13 December 2019

**WARNERVALE PUBLIC SCHOOL
RESPONSE TO SSDA SUBMISSIONS**

We refer to the proposed Warnervale Public School and the recently received SSDA submission. We provide below a response to the submission items related to civil engineering and stormwater.

Drawing Number	80818098-01-CI-1101	Revision	4
----------------	---------------------	----------	---

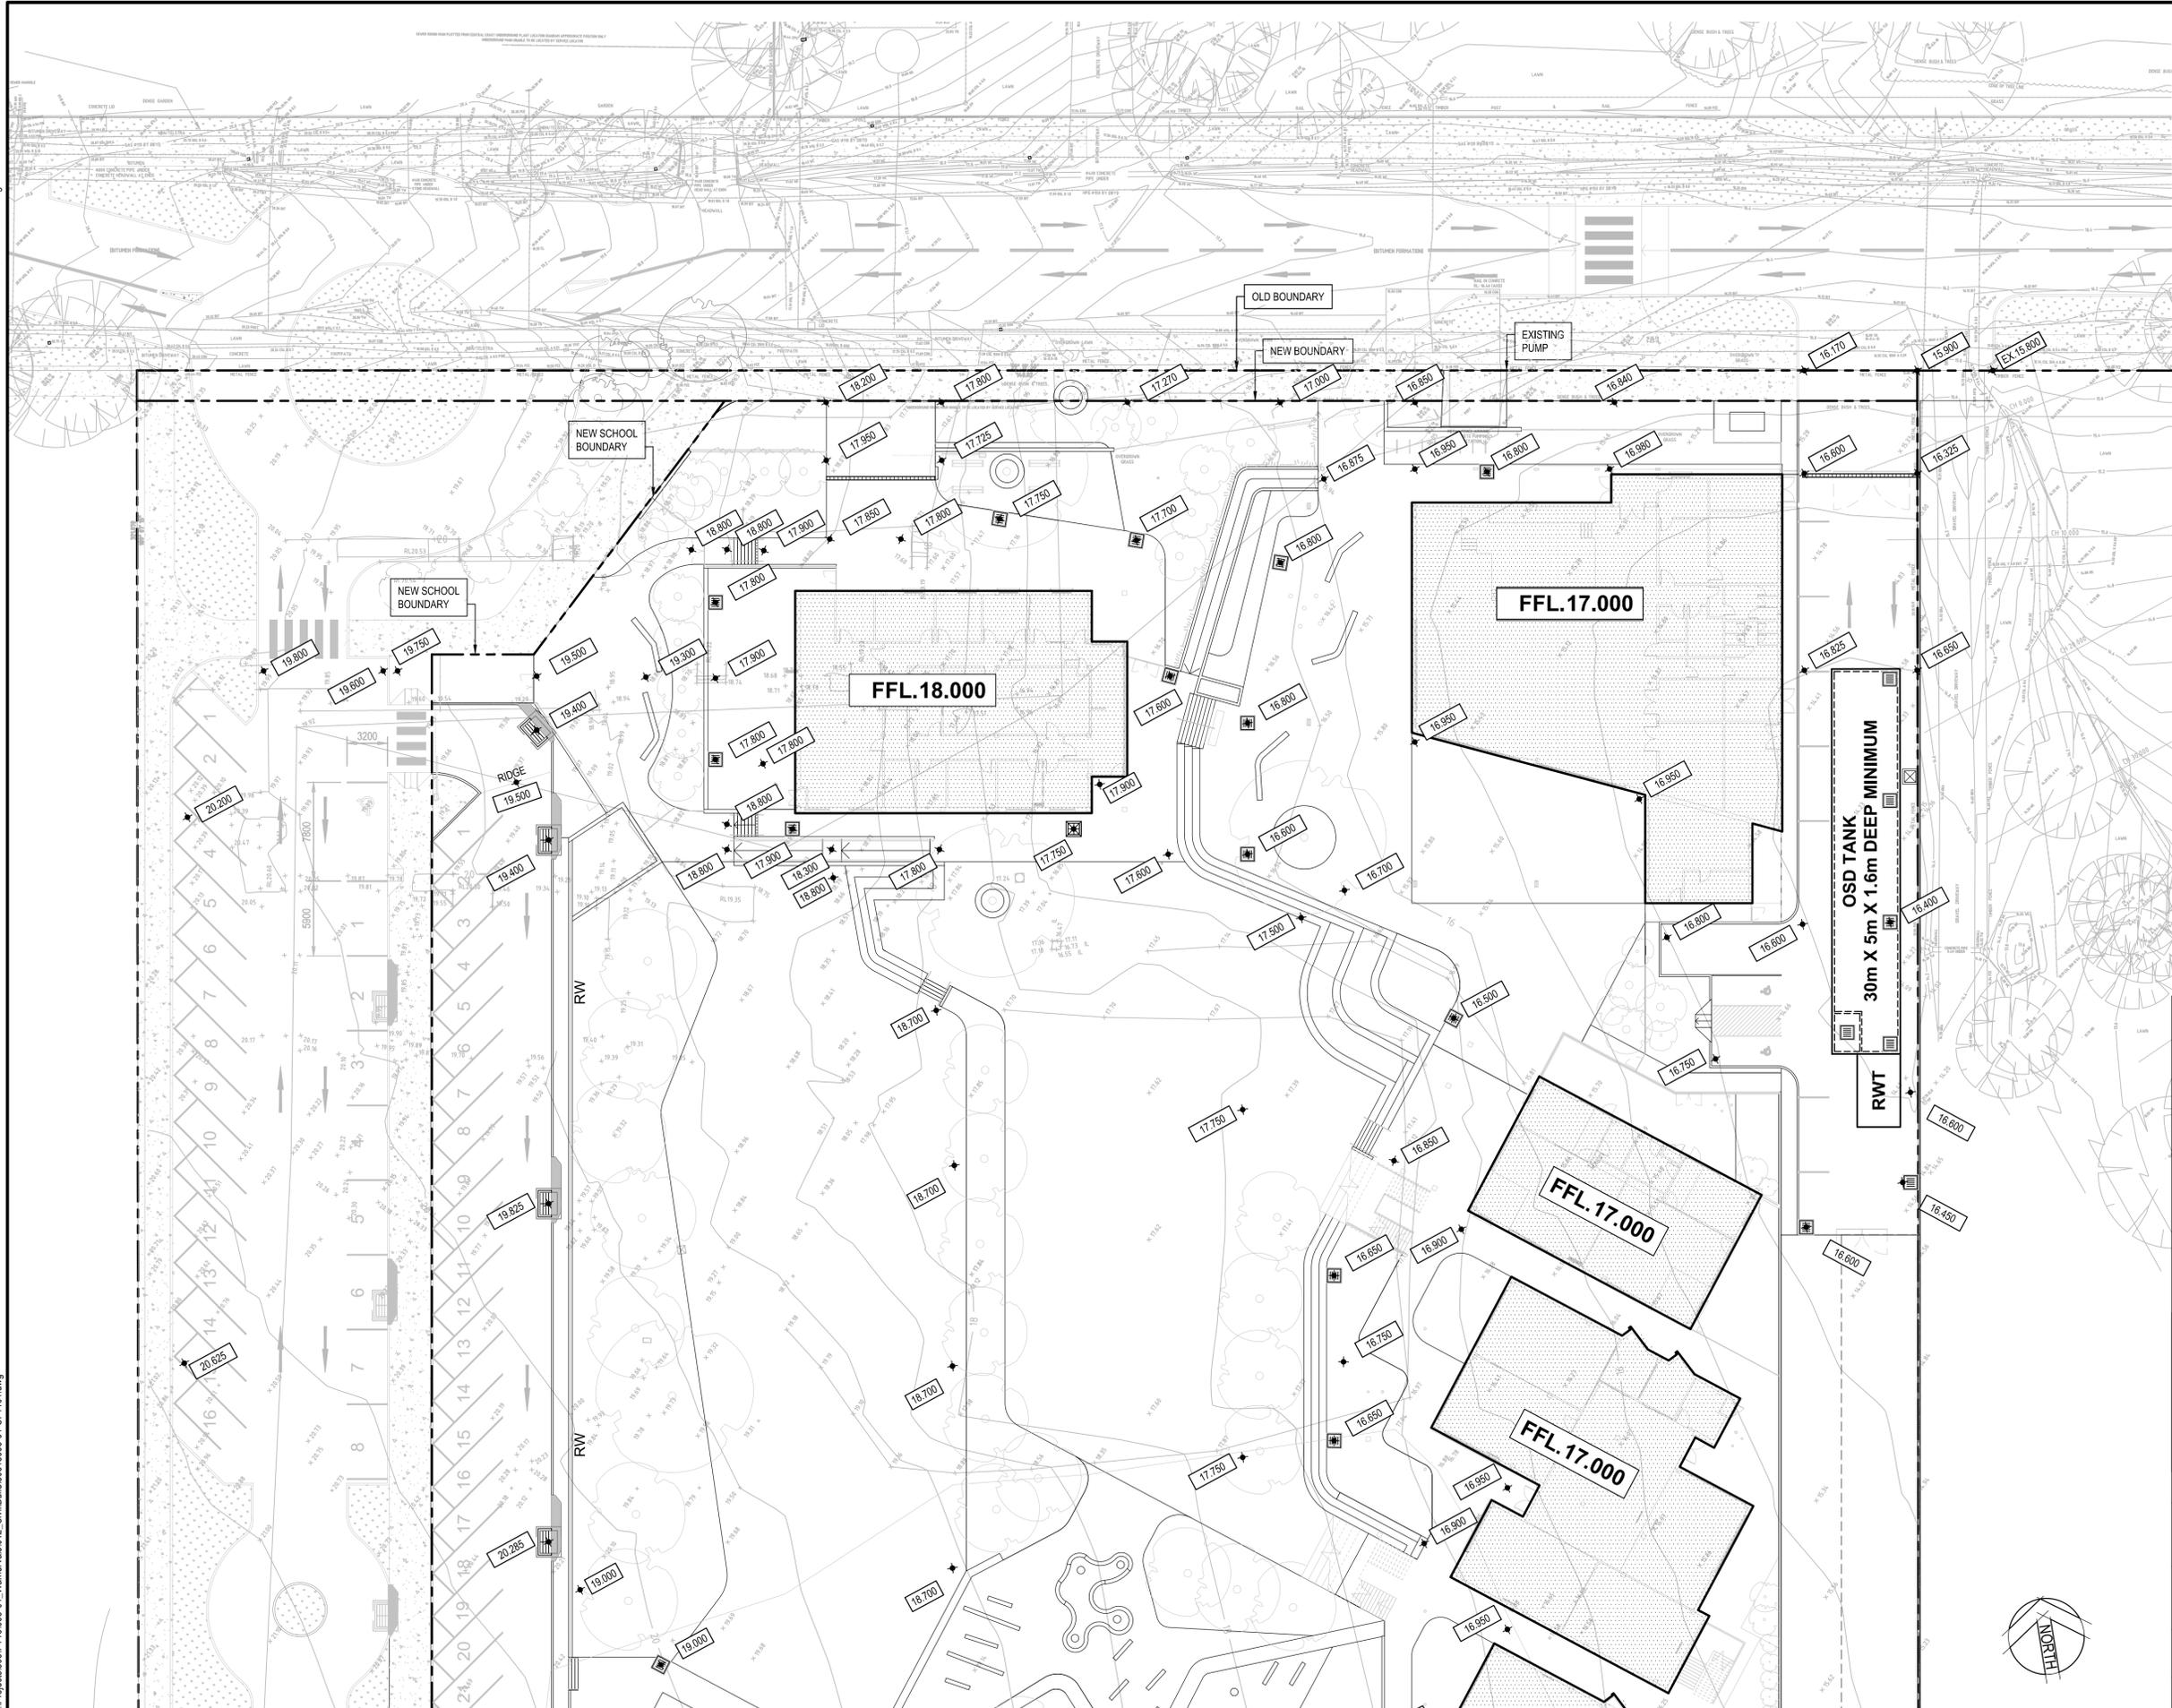
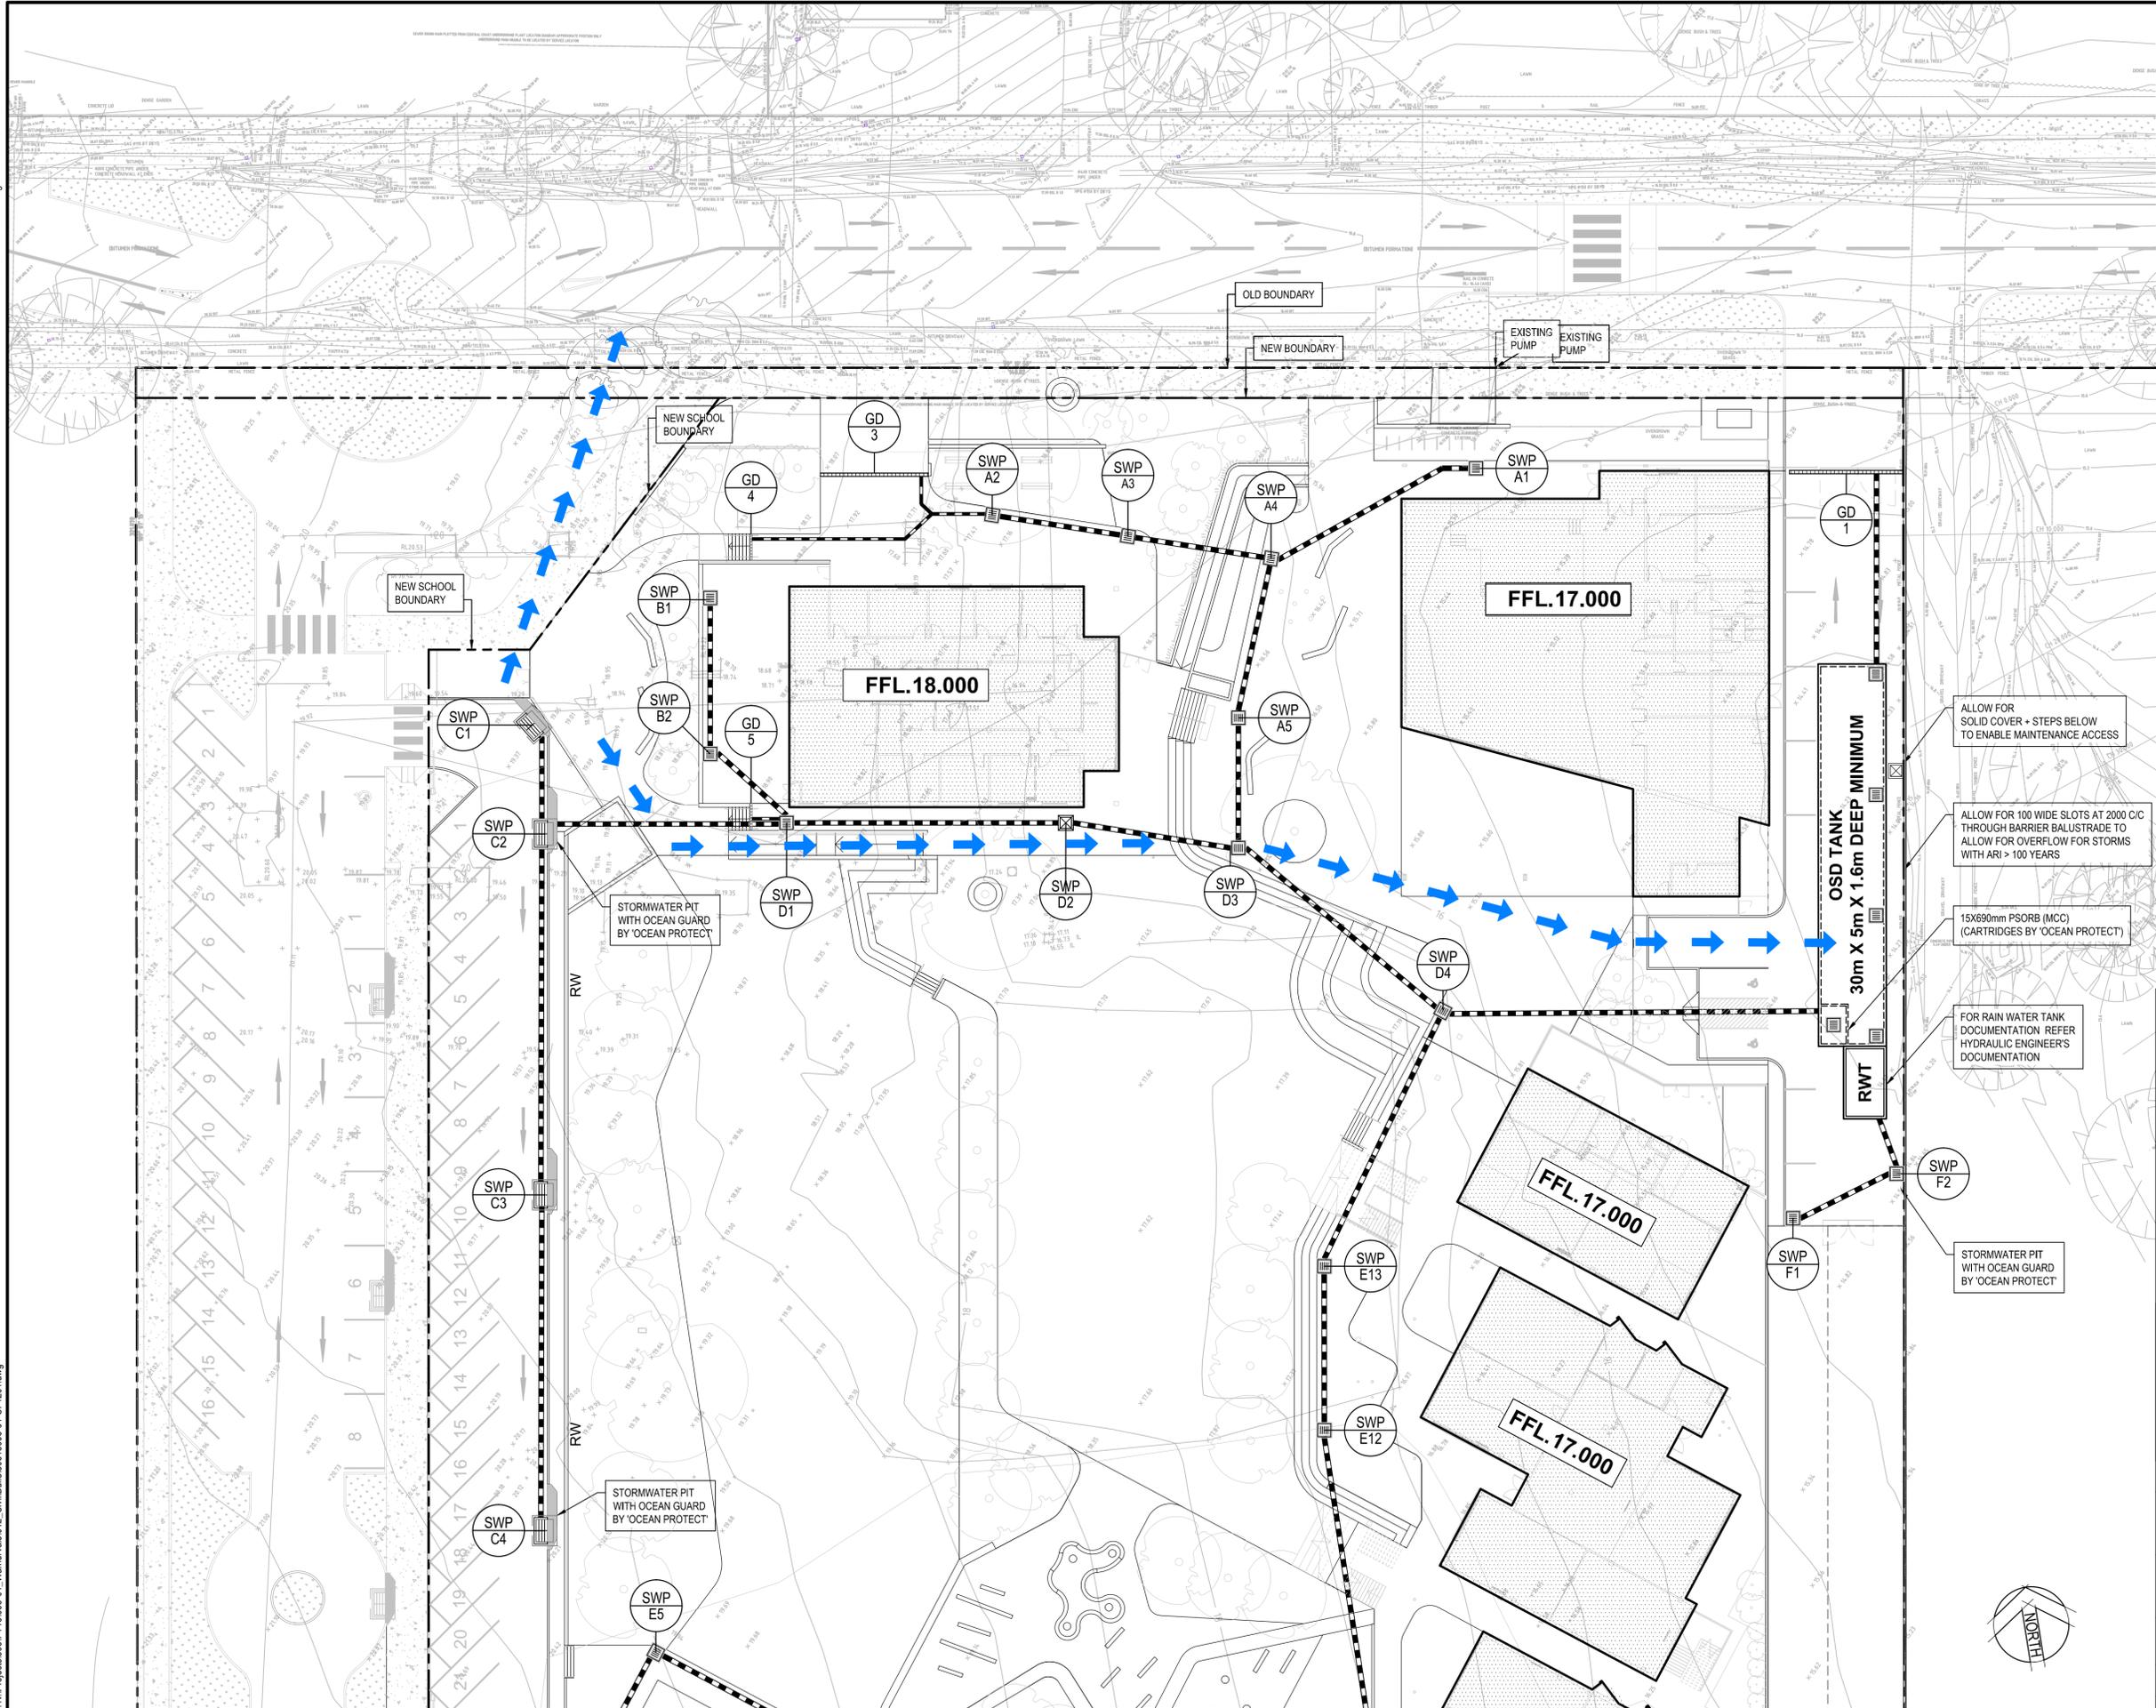
Comment:

The proposed roundabout will need to accommodate U-turns for buses.

Comment:

The roundabout must be designed in accordance with the Austroads Guide to Road Design.

We confirm that the proposed roundabout on Warnervale Road that will service the proposed school will be designed to accommodate U-turns for 12.5m long buses.

We confirm that the proposed roundabout on Warnervale Road that will service the proposed school will be designed in accordance with Austroads Guide to Road Design: Part 4B – Roundabouts, and relevant RMS supplements.

CLIENT  
DEPARTMENT OF EDUCATION  
DRAWING TITLE:  
SITE CONTEXT - EXISTING

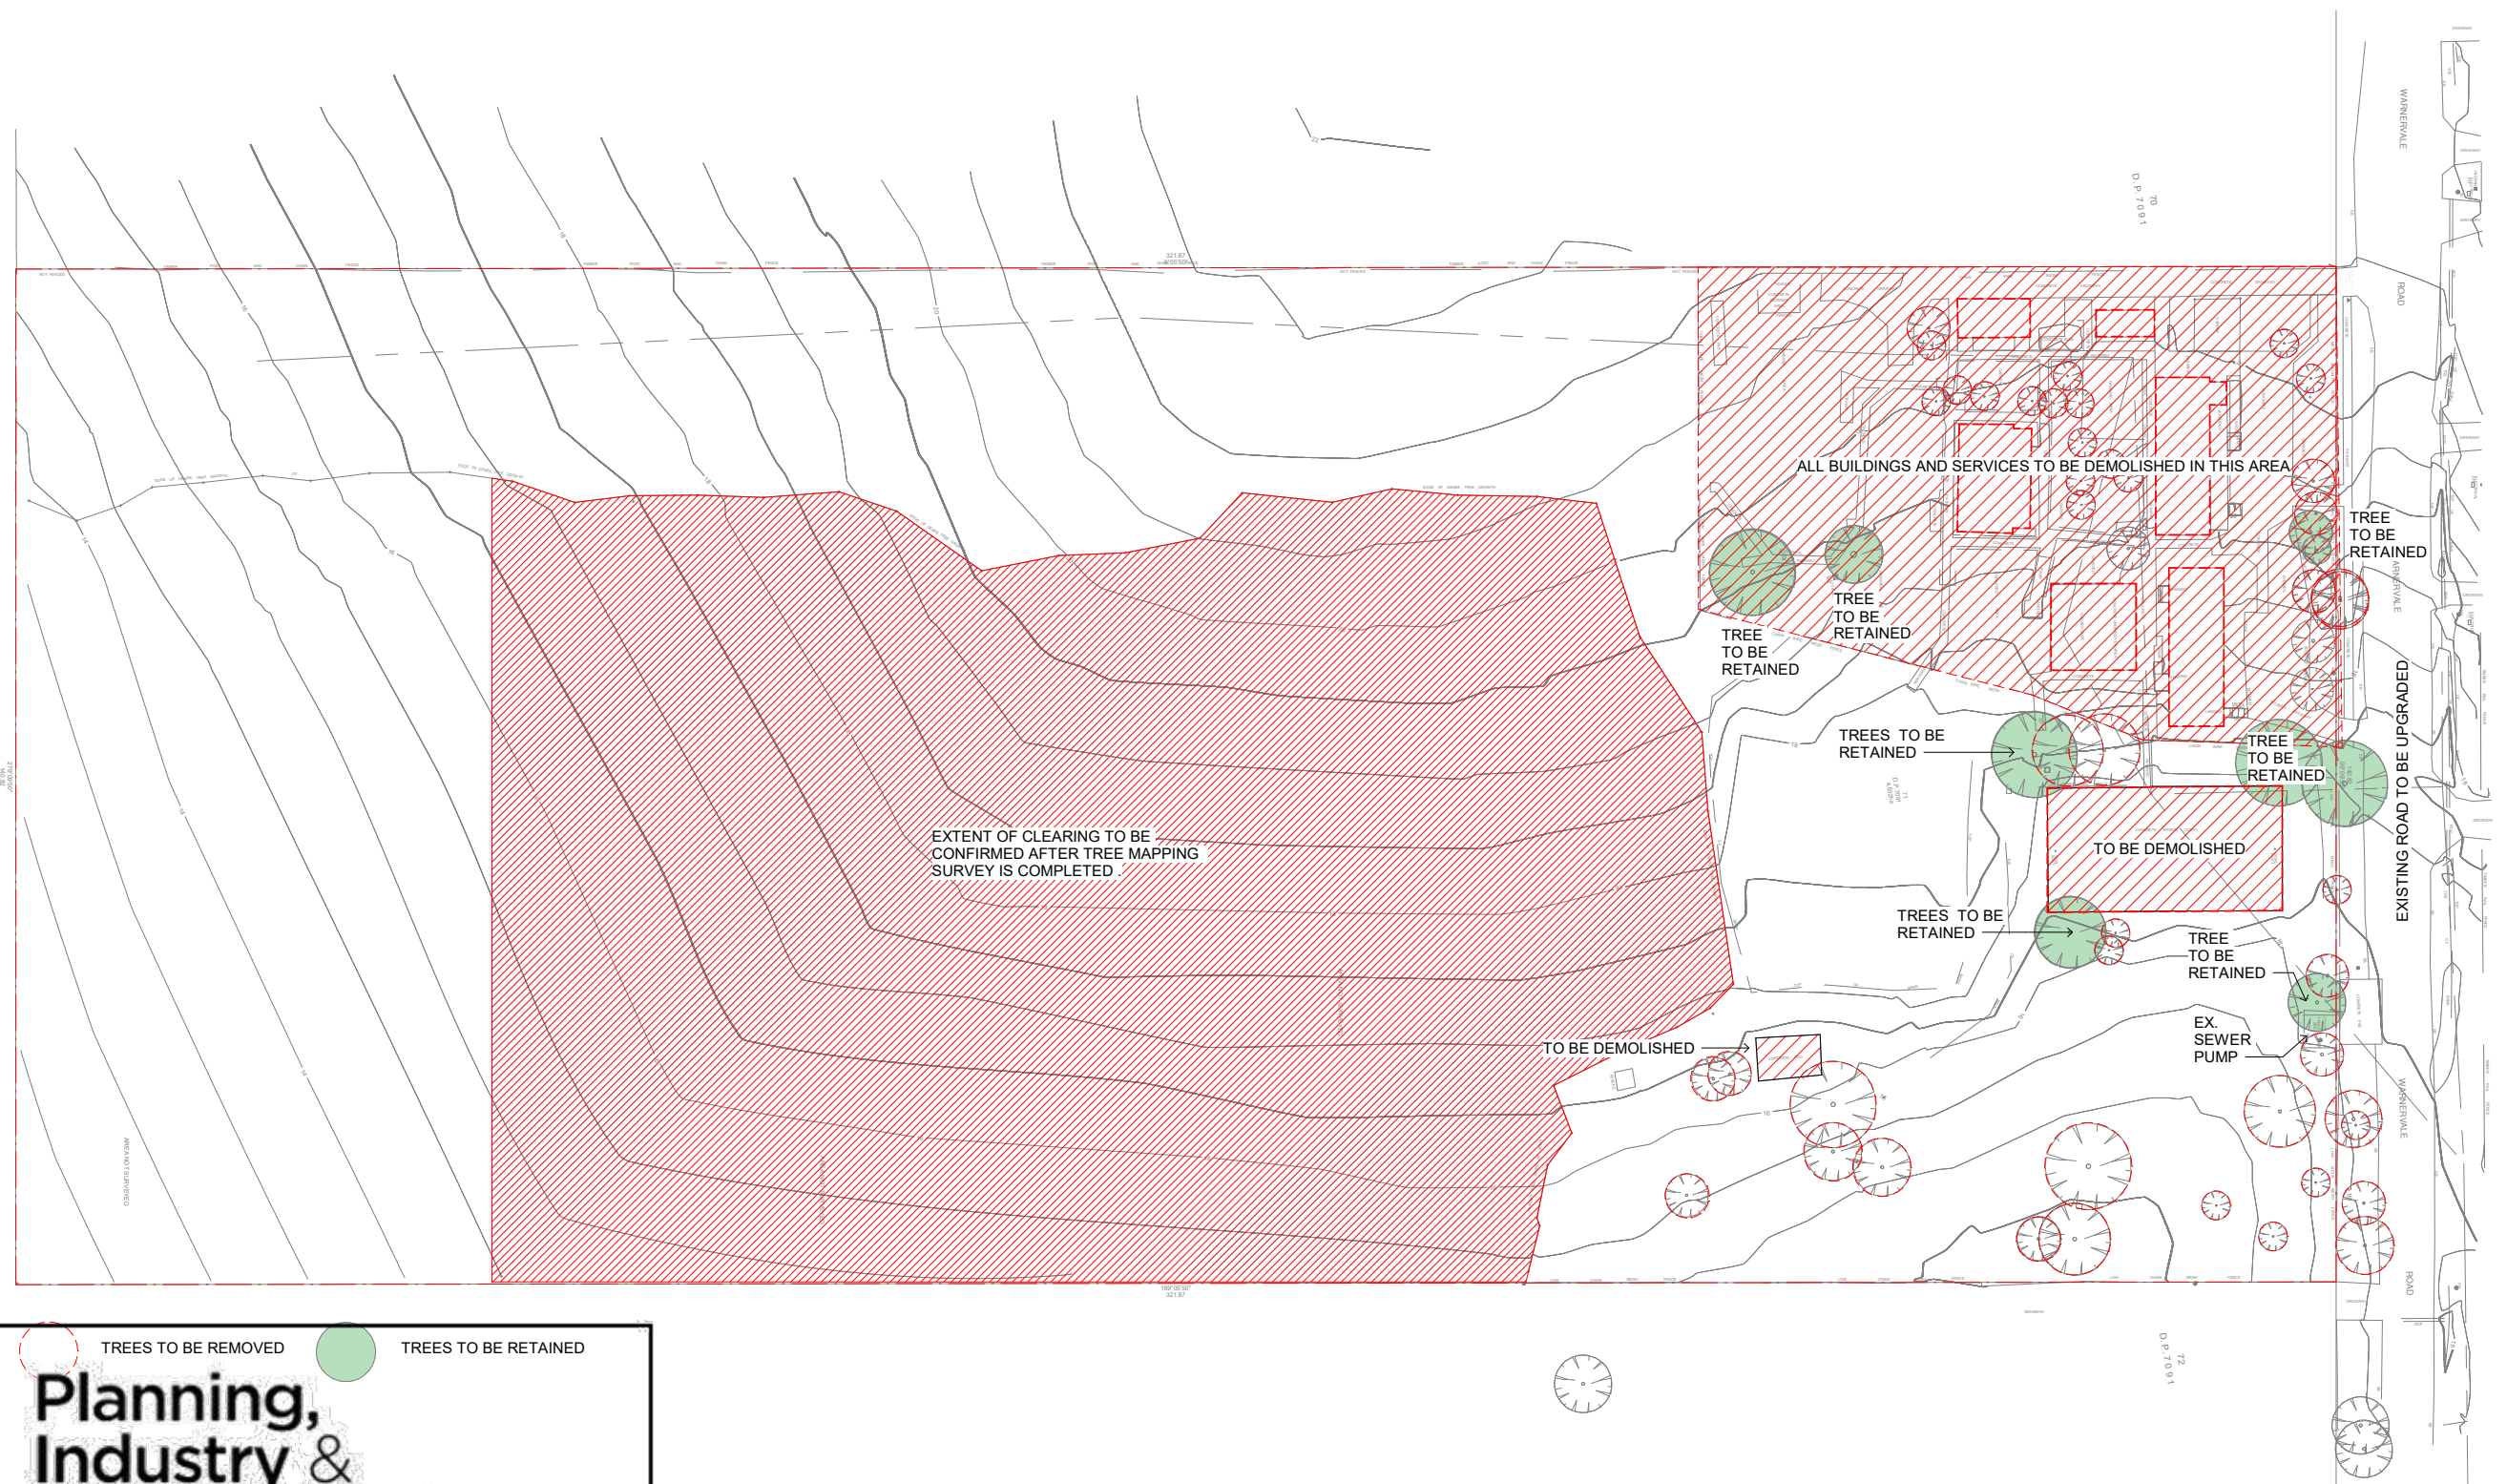
The proposed emergency service route shown on the Site Context Plan shall comply with section 4.1.3 (3) of Planning for Bush Fire Protection 2006 at a minimum.

We confirm that the proposed emergency service route will comply with Section 4.1.3 (3) of the Planning for Bush Fire Protection 2006. This includes compliance with trail width, grade, construction materials etc.
